Mountain View Electric Association, Inc. (MVEA) has these comments about the following:

**Project Name: Oberle Vacation & Replat**

**Project Number: VR 1819**

TITLE
Oberle Vacation & Replat in
Section 11, T11S, R67W, 6th
P.M., El Paso County, Colorado

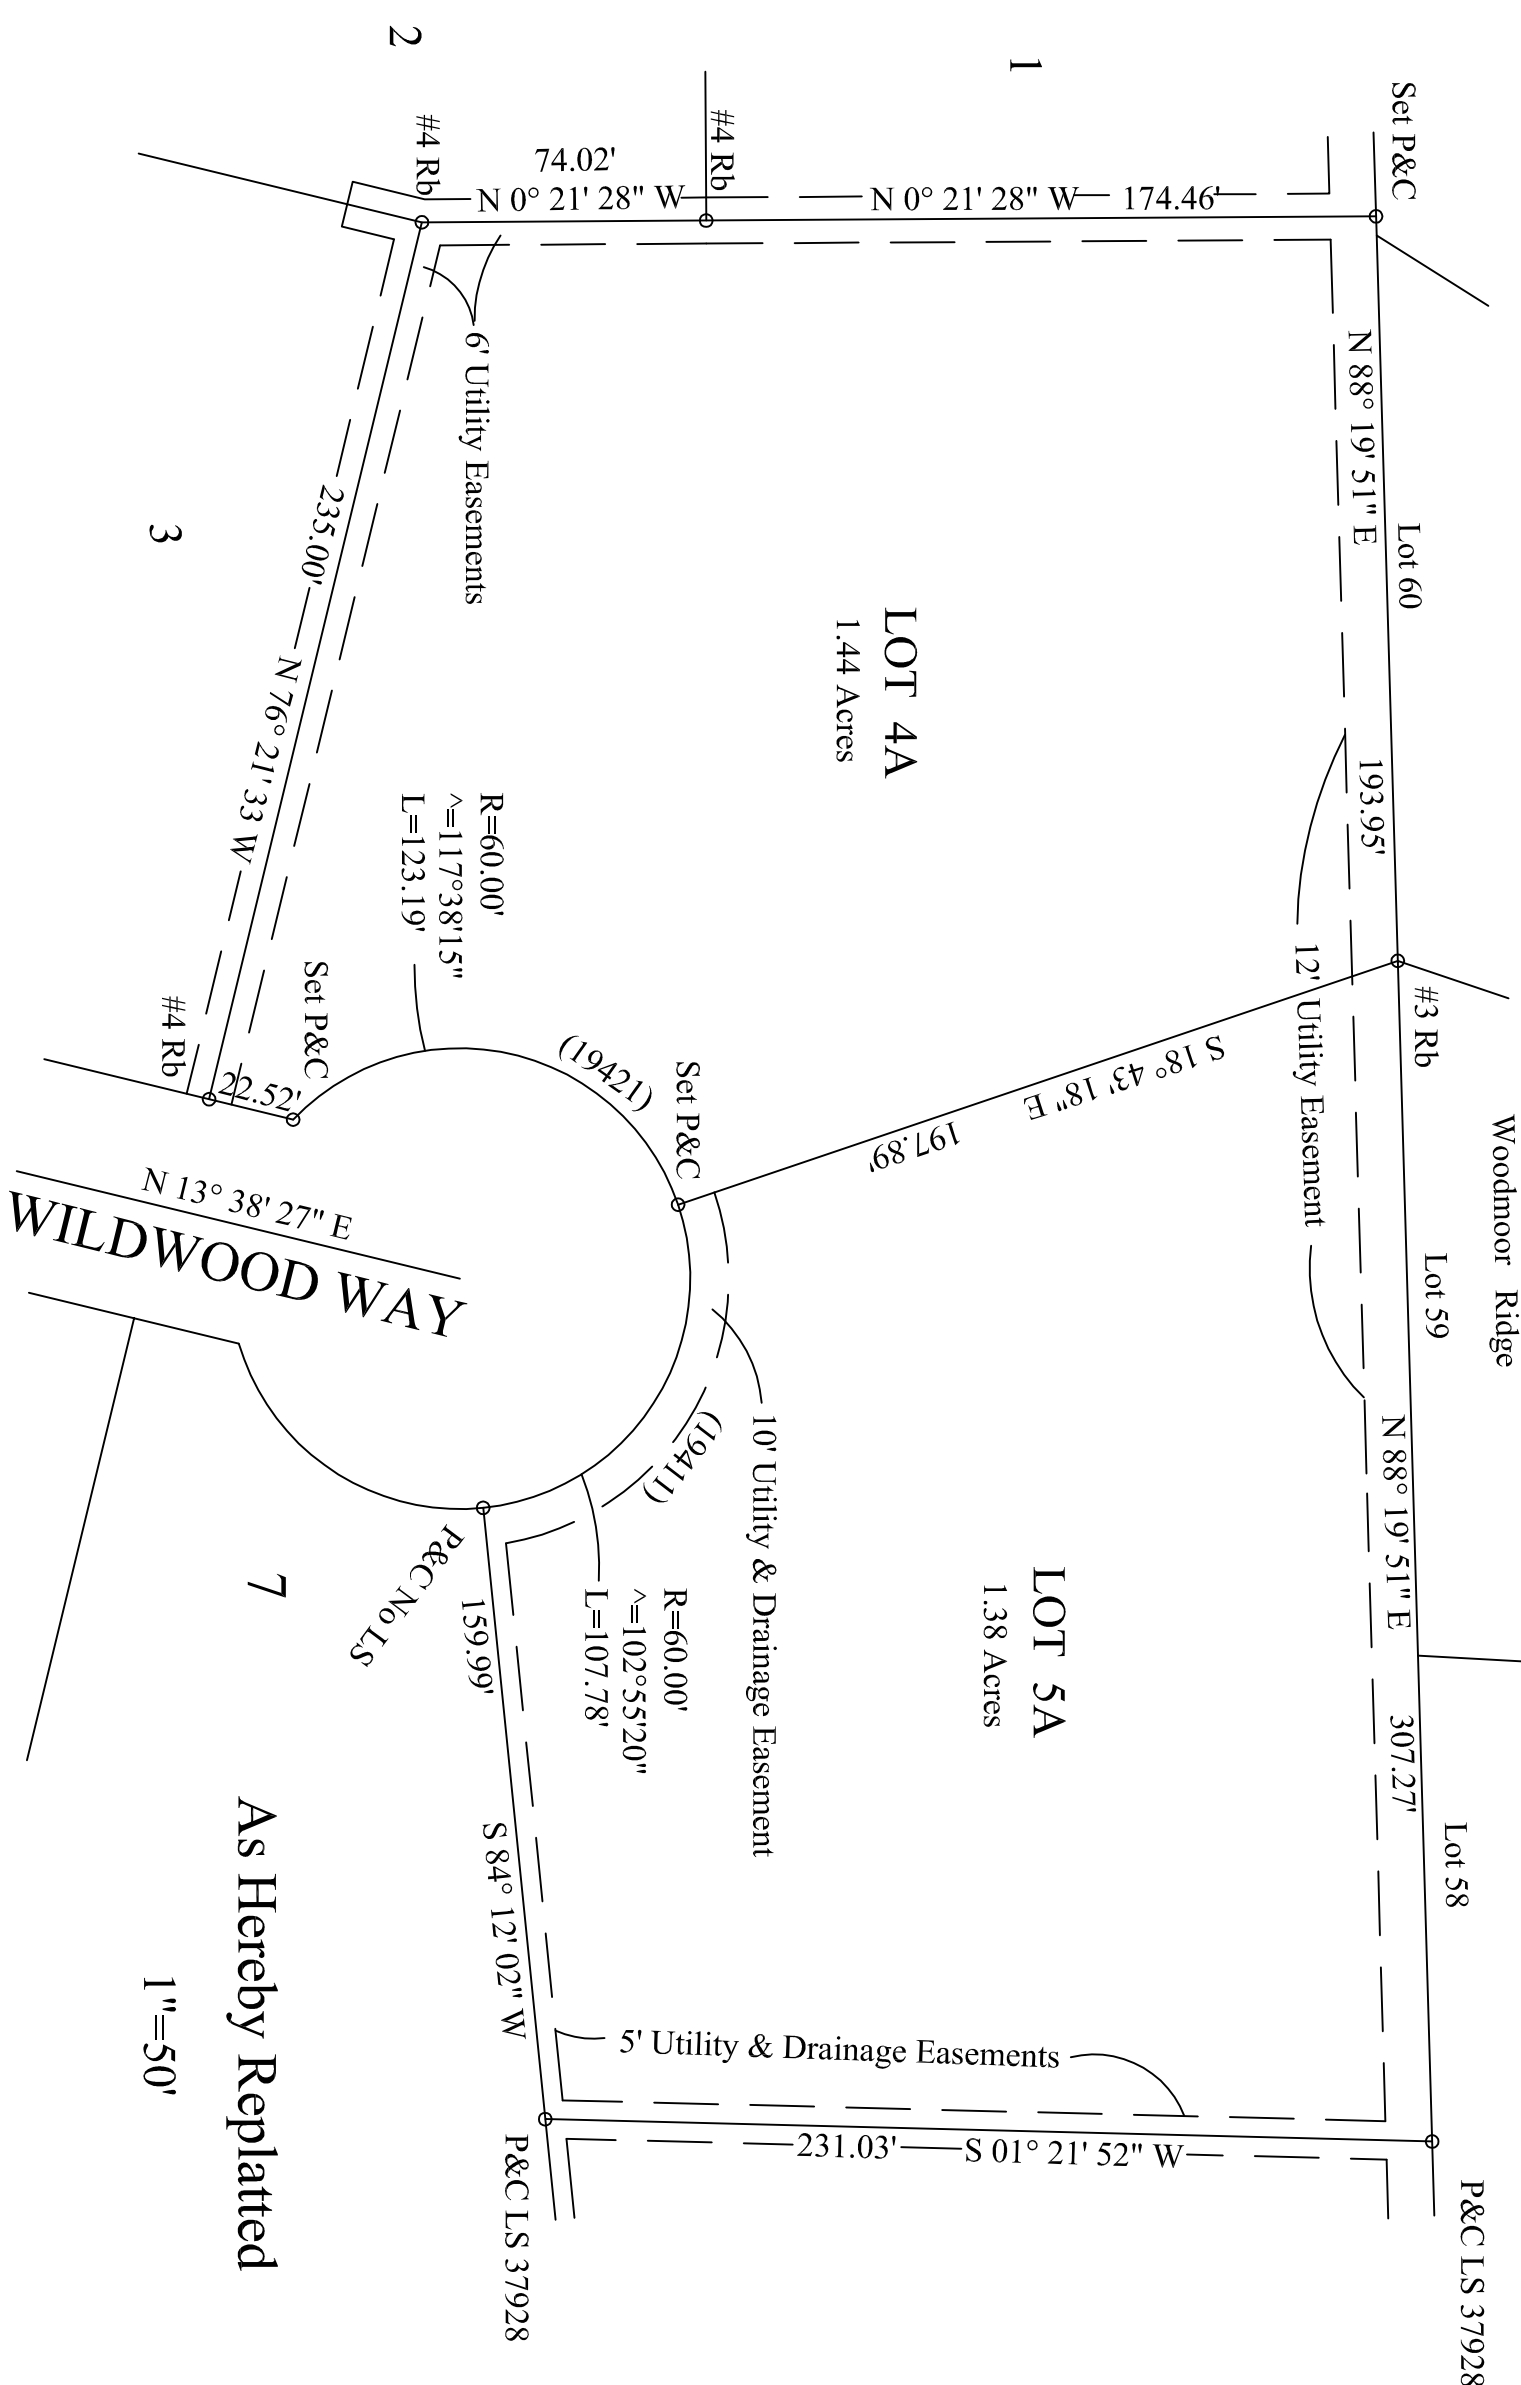
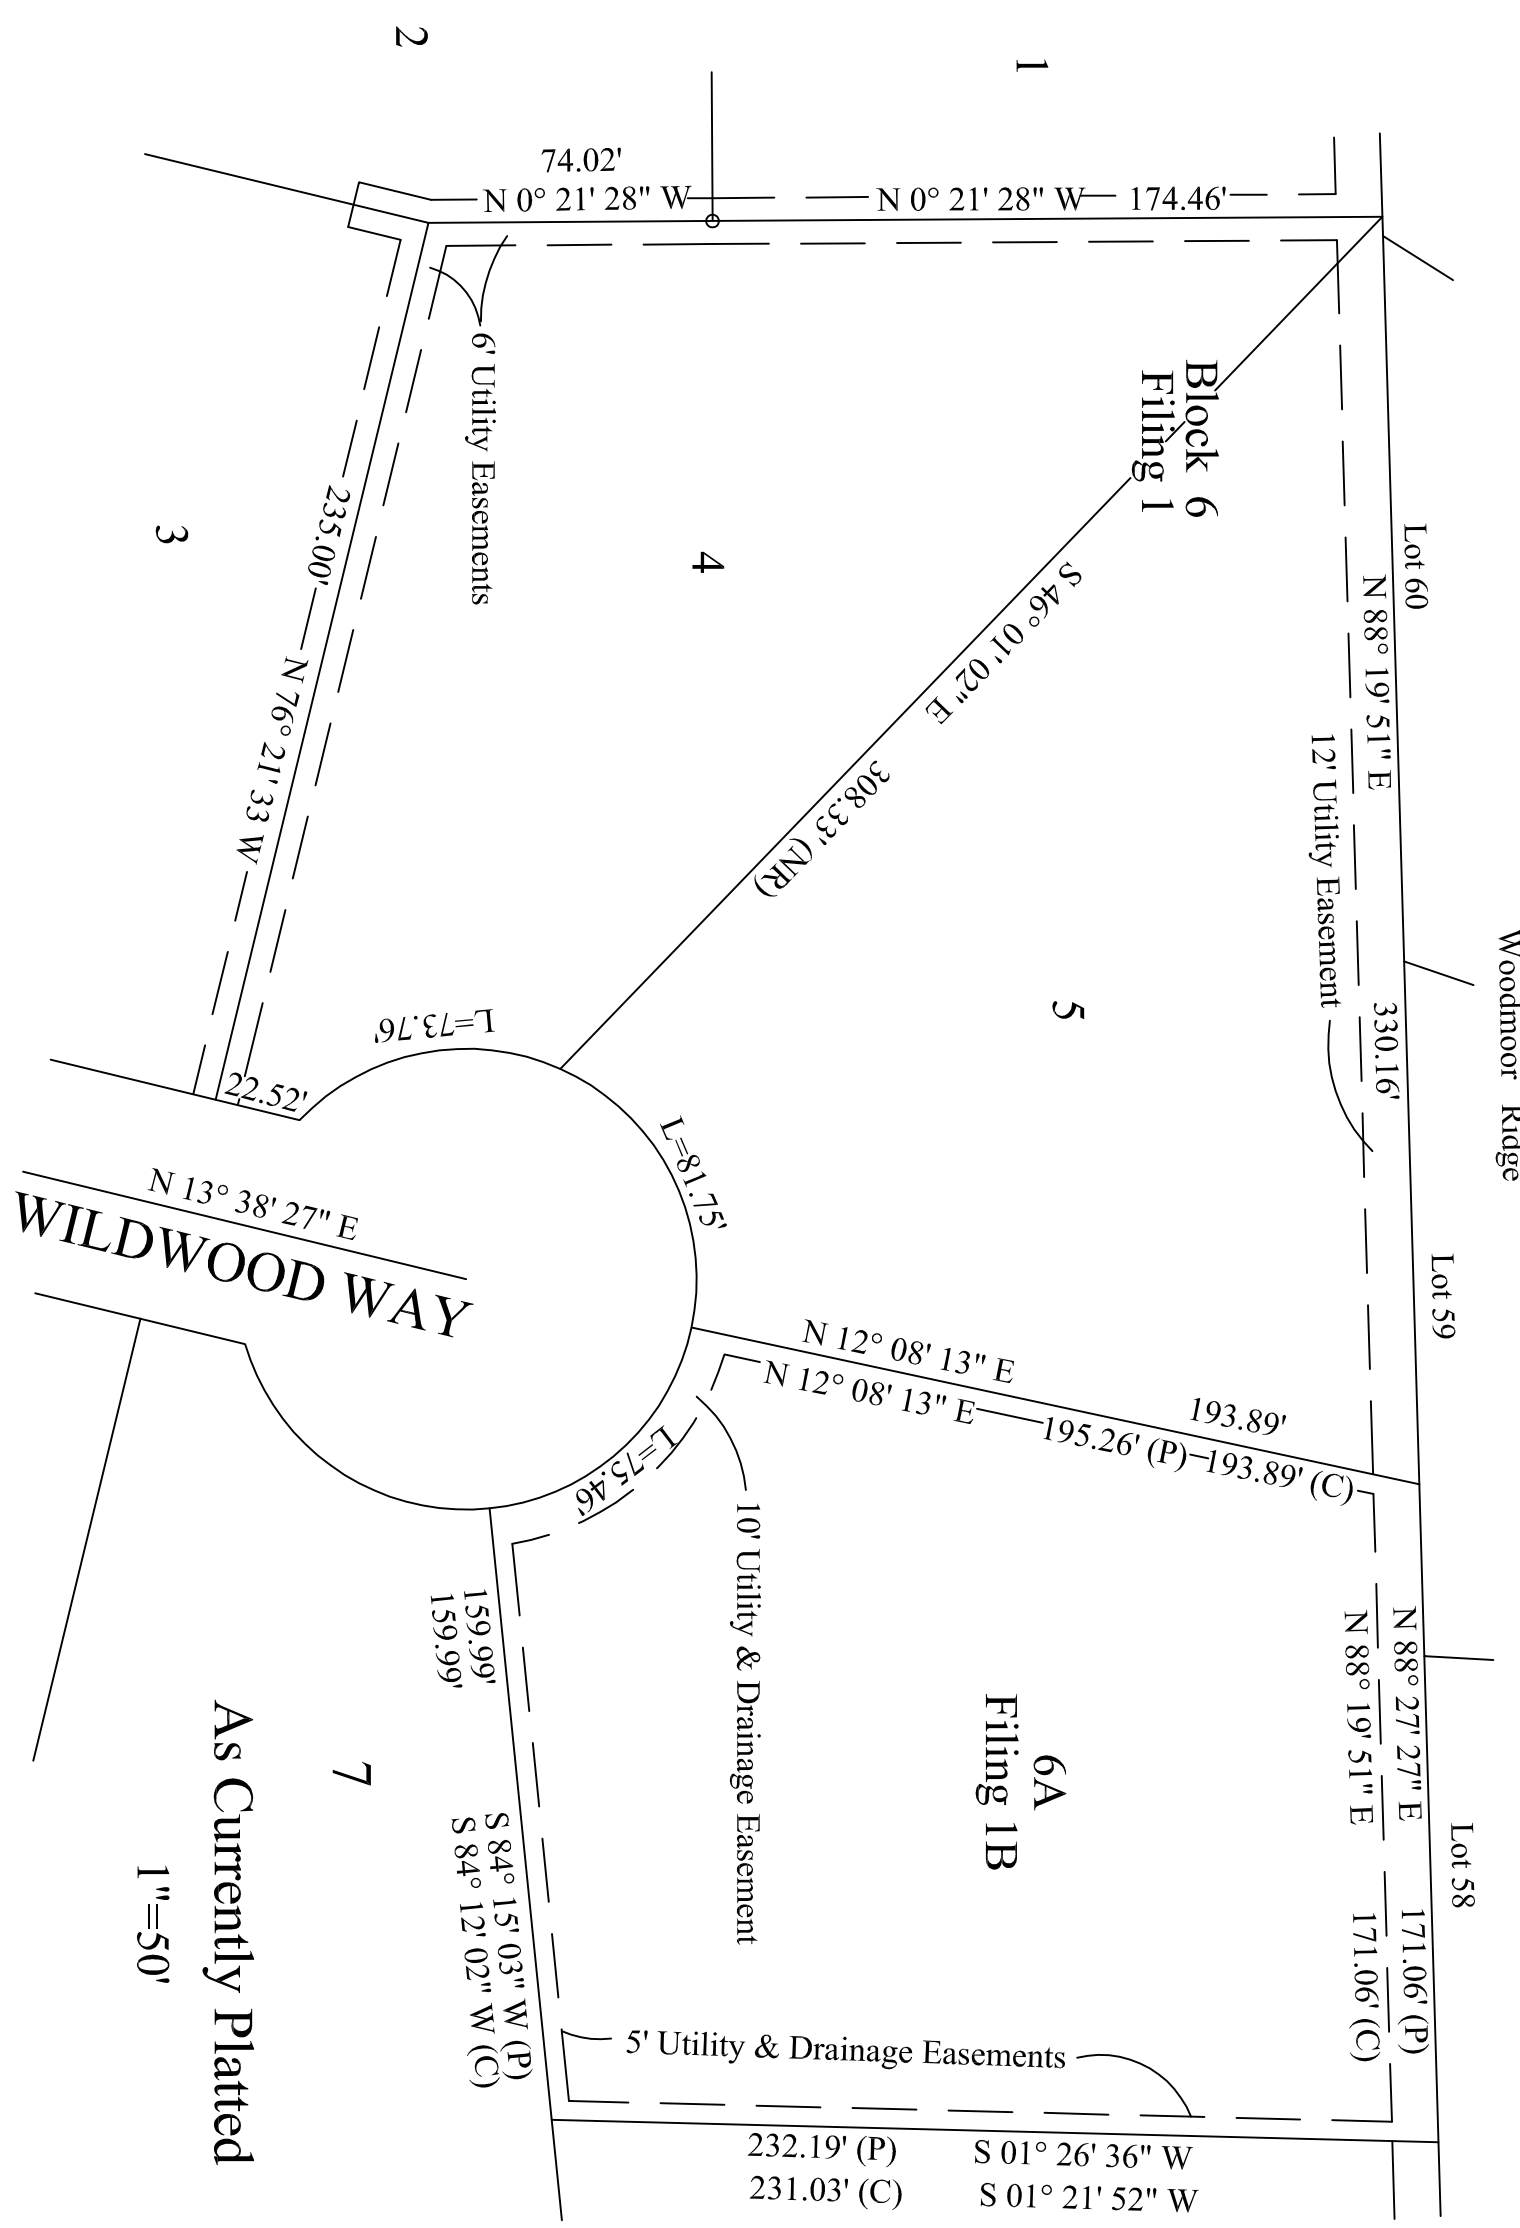
MVEA places electric facilities along the common lot line within utility easements to provide service to both residential lots. If the replat is approved, MVEA facilities will no longer be on the common lot line. If there is any removal, relocation or redesign of facilities it will be at the expense of the applicant.
